## KITTITAS COUNTY DEPARTMENT OF PUBLIC WORKS

### MEMORANDUM

TO: Community Development Services  
FROM: Taylor Gustafson, Environmental/Transportation Planner  
DATE: December 21, 2018  
SUBJECT: Public Works Review of BLA BL-18-00015 (Crossfire) TG

CRUISE & ASSOCIATES
 PROFESSIONAL LAND SURVEYORS
 217 East Fourth Street P.O. Box 959
 Ellensburg, WA 98926 (509) 962-8242
CROSSFIRE FARMS PROPERTY

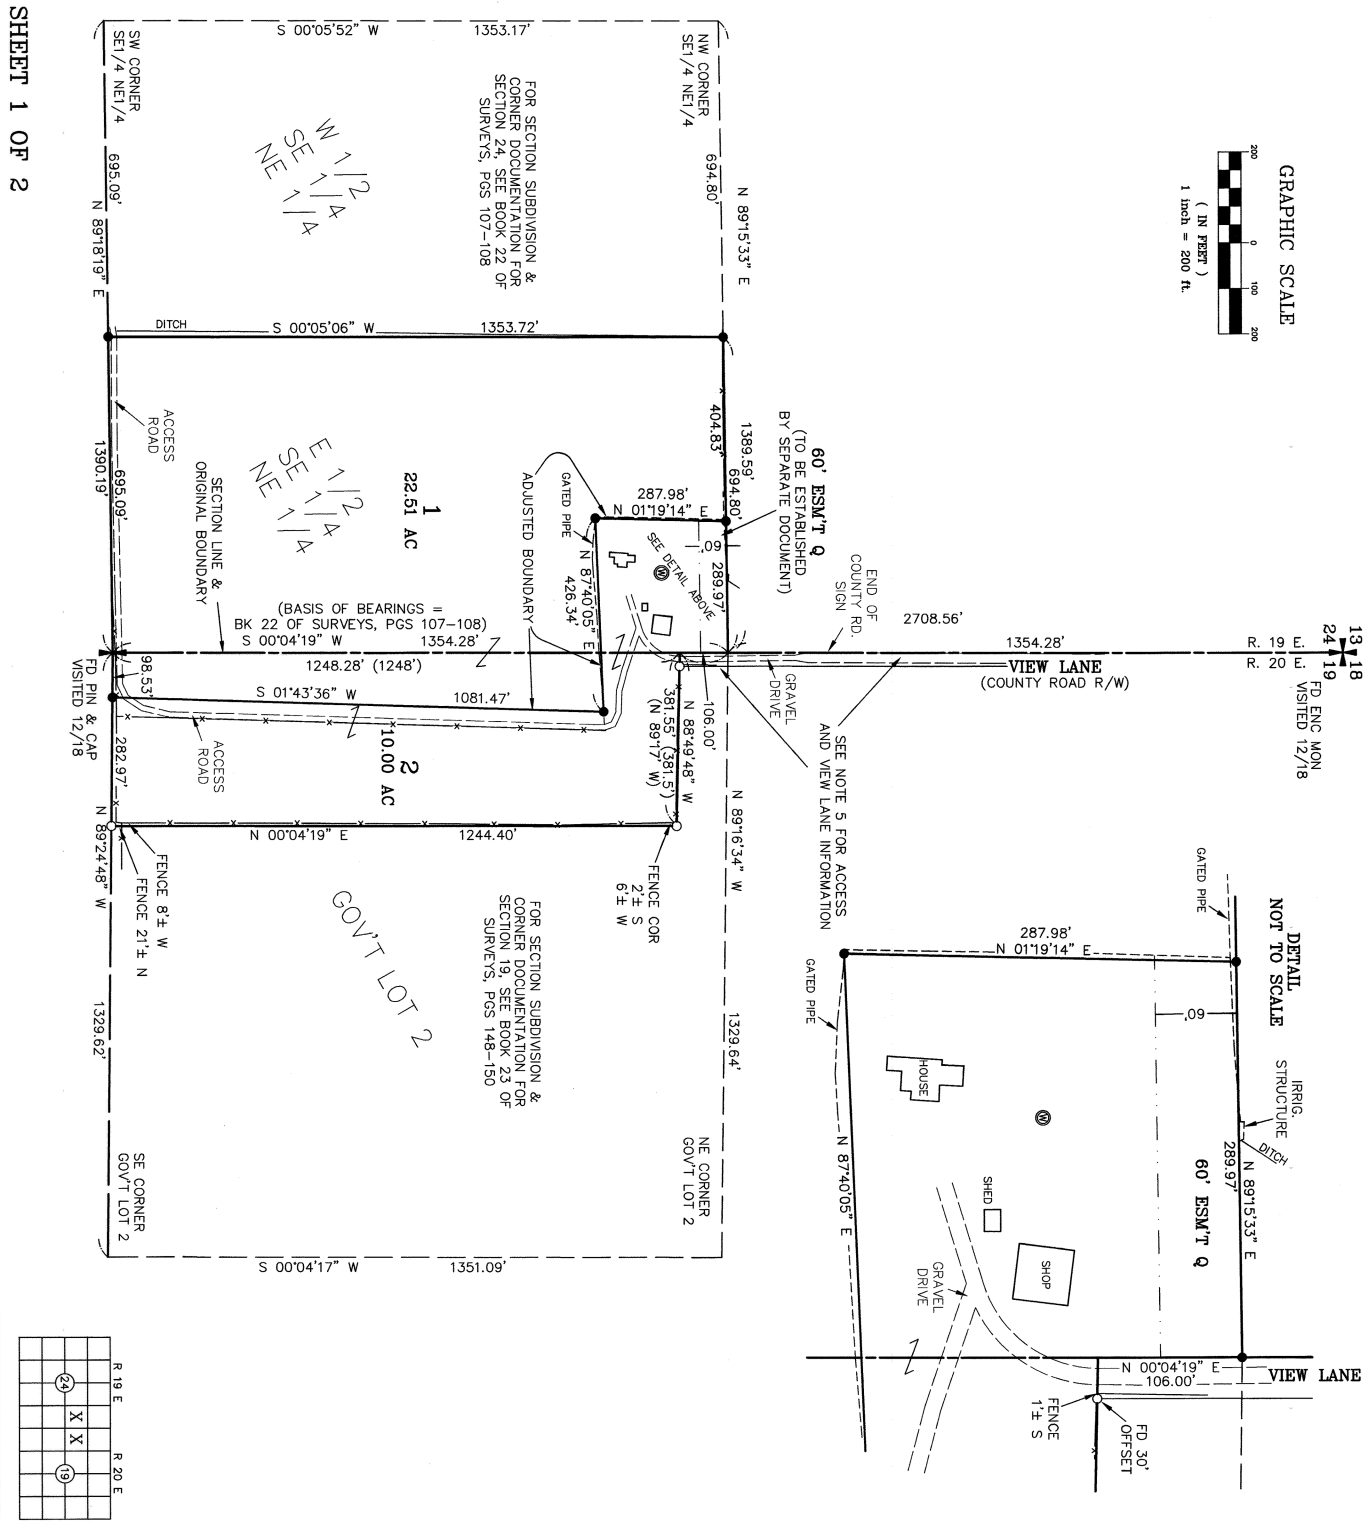
1. Proof of access across the western most 30 feet of the lot adjacent and easterly of lot 2 needs to be provided either through a recorded easement or through prescriptive rights.

2. There is a gap between the end of the County Road, and the parcel to be adjusted. Very little exists in the county documents regarding View Lane, but it appears that the County road is 0.22 miles of 30' wide right of way, which would place the end of the road near the "End of County Road sign".

The best solution would be to perfect the access by filing an easement, if underlying landowners are agreeable. At minimum, a statement showing the portion of road across private property as an easement by prescription, showing the area involved.
